**Great North Road Solar and Biodiversity Park – Issue Specific Hearing 3 (ISH3)**

**Wednesday 4<sup>th</sup> February 2026**

Summary of Verbal Representations from Newark and Sherwood District Council (NSDC)

1:32,000 Scale @ A3

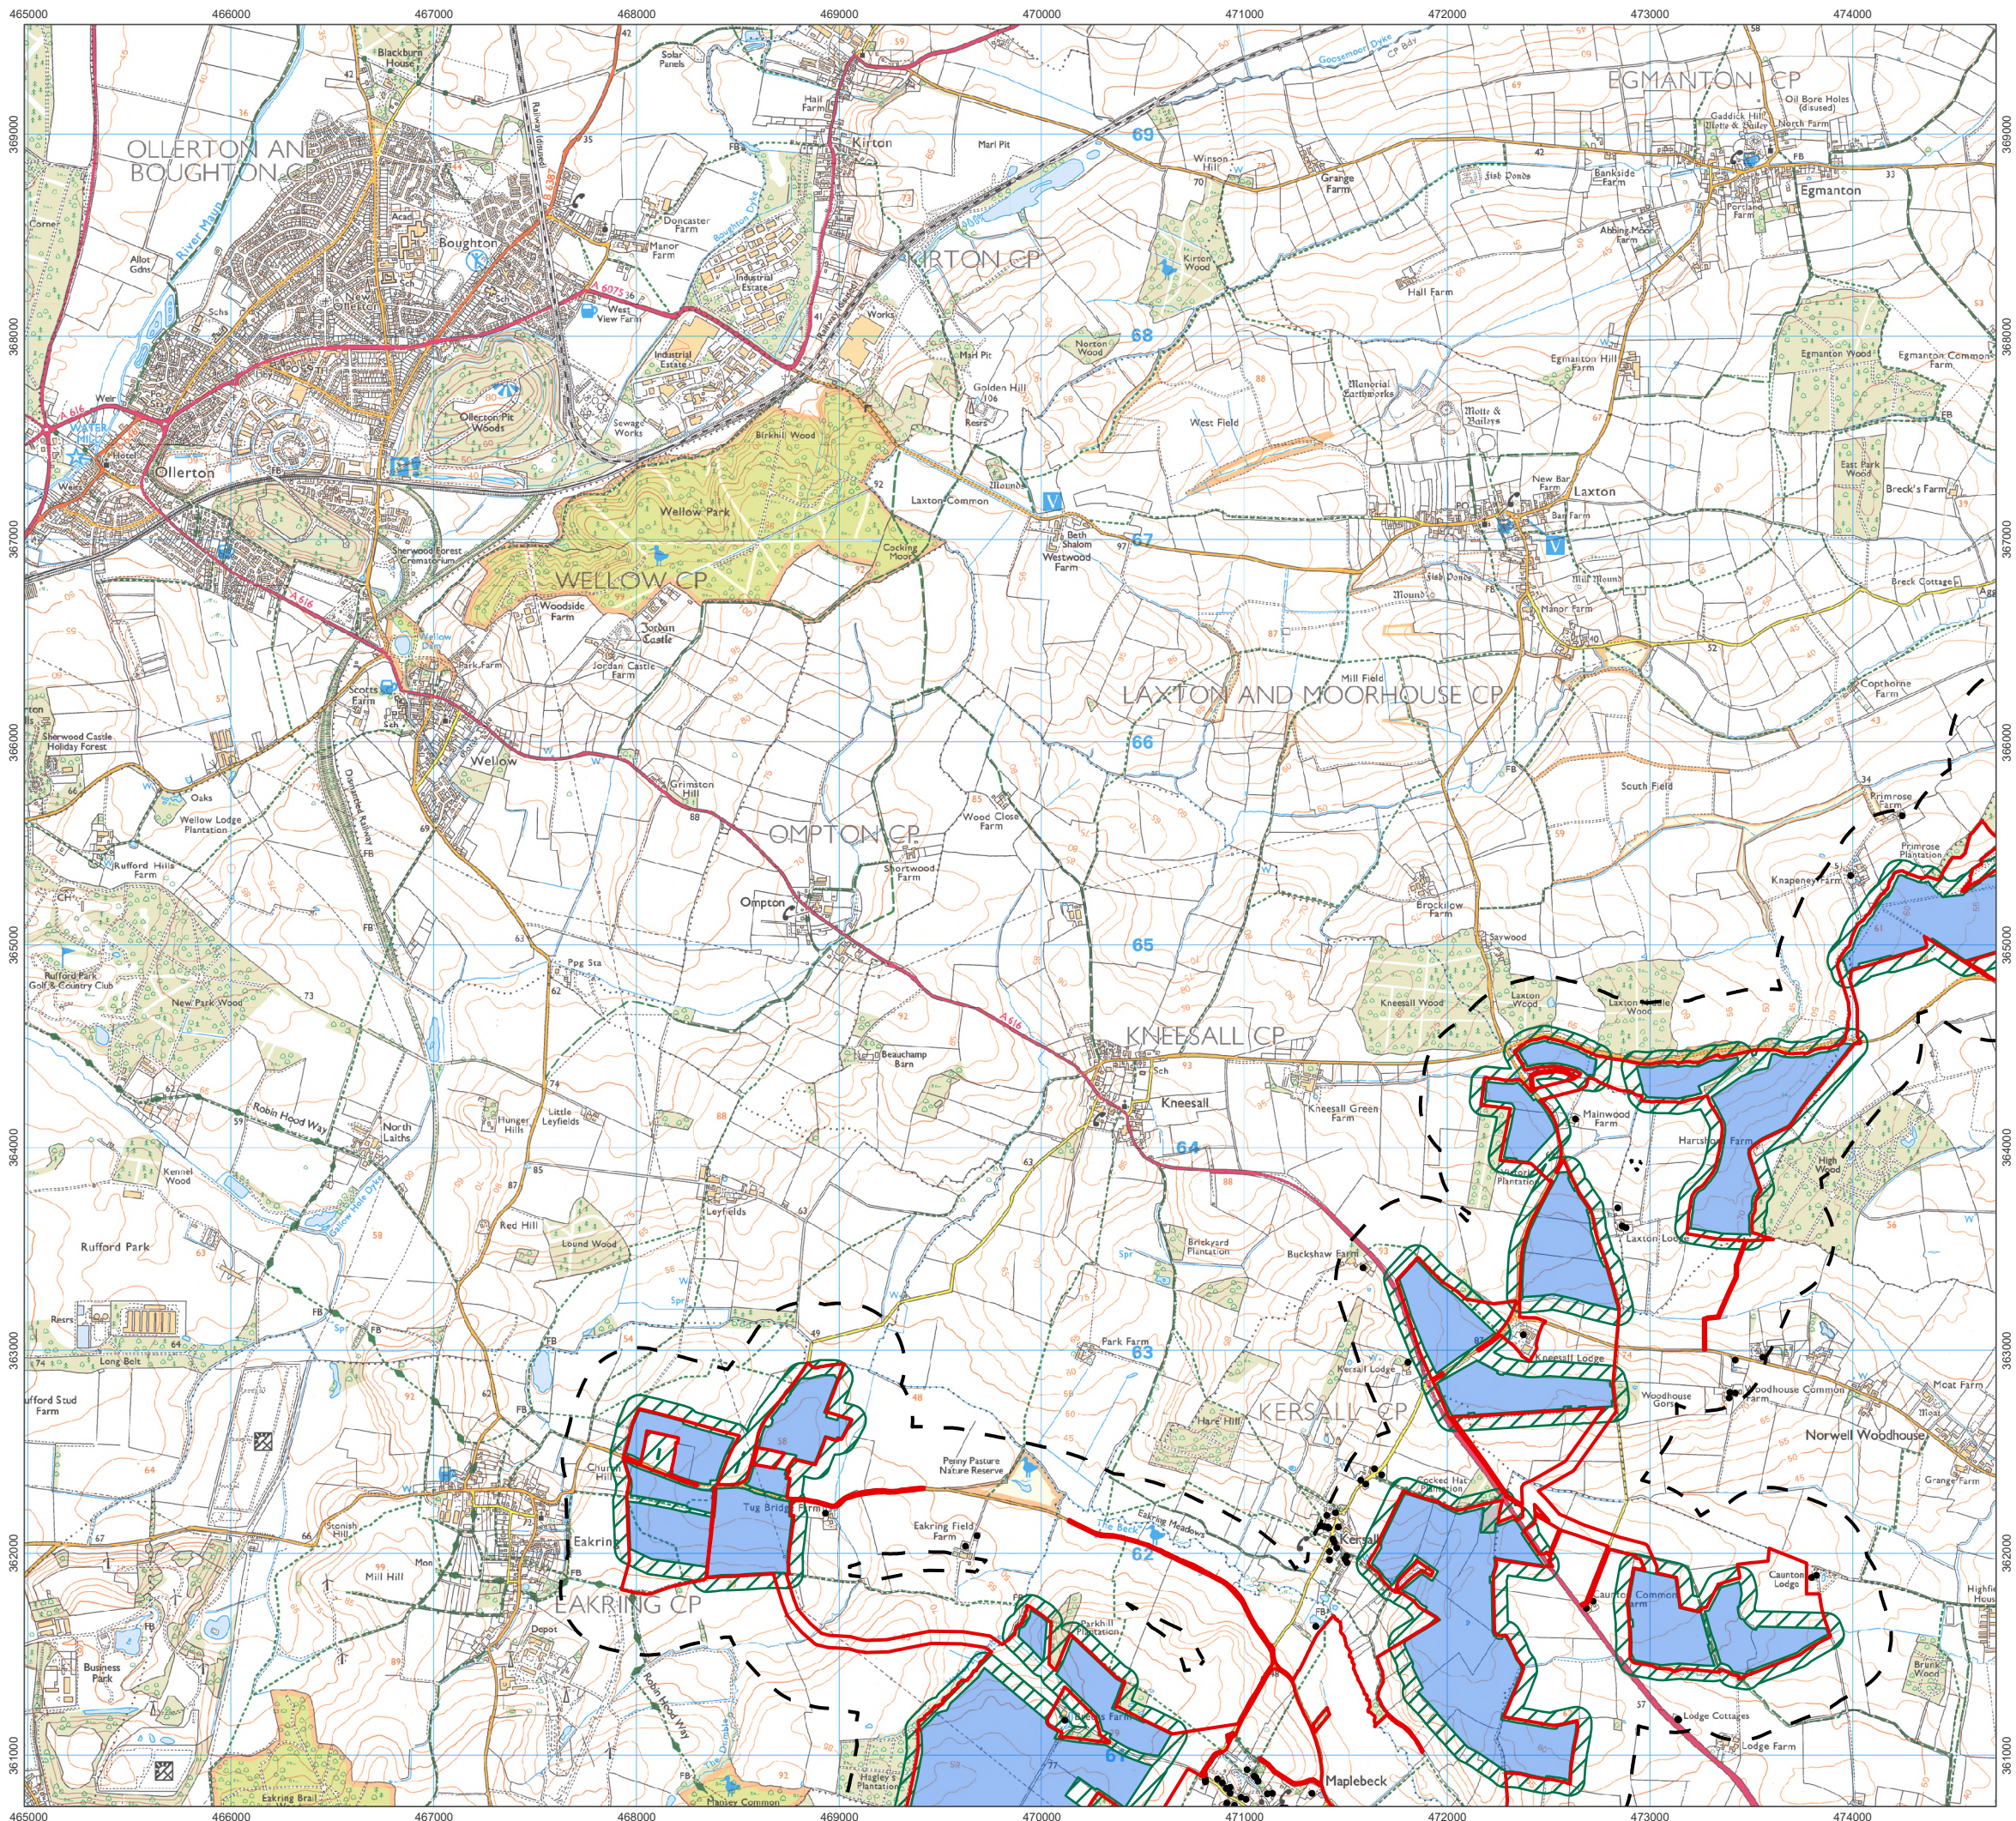
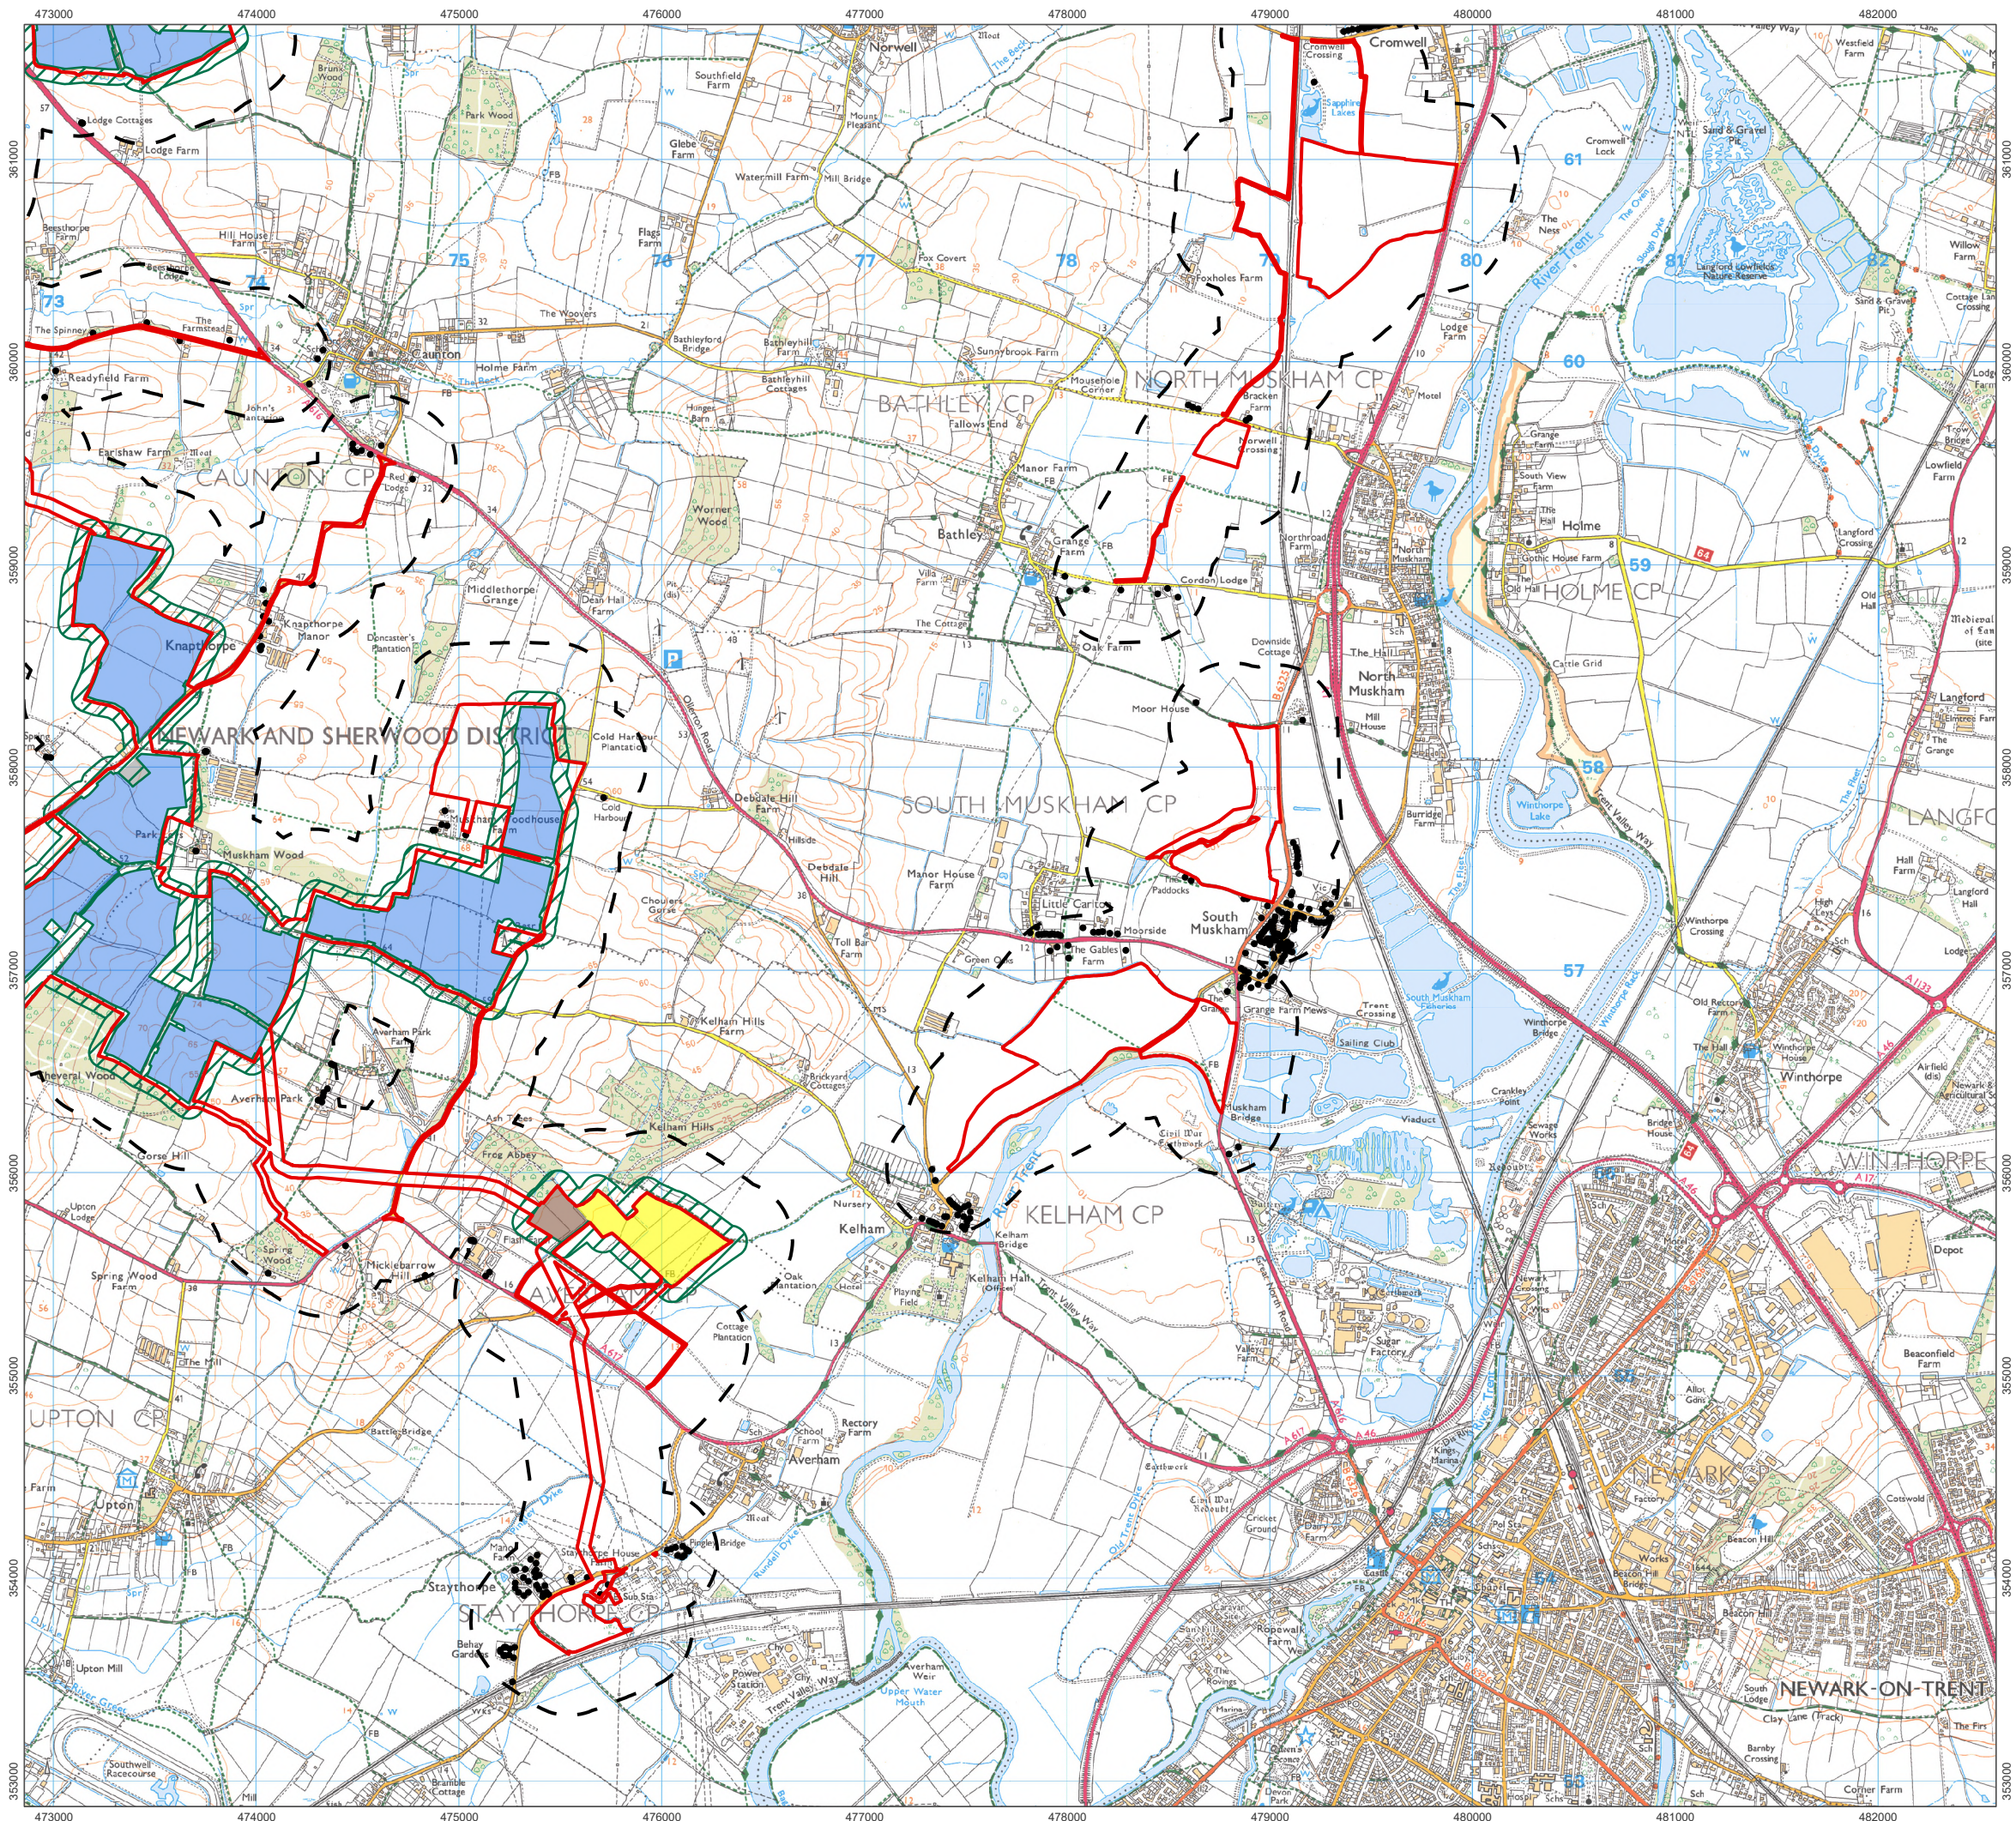
19. NSDC confirmed their opinion that the applicant has used appropriate thresholds for noise, derived from appropriate standards. Receptors have been identified within areas where noise levels are above the threshold, however the modelling assumes a 'worse case' with all noise sources operating continually and simultaneously, with no screening or other attenuation. Details of measures to control noise are to be provided through submission of a Construction Environment Management Plan (CEMP) and Noise Management Plan (NMP).
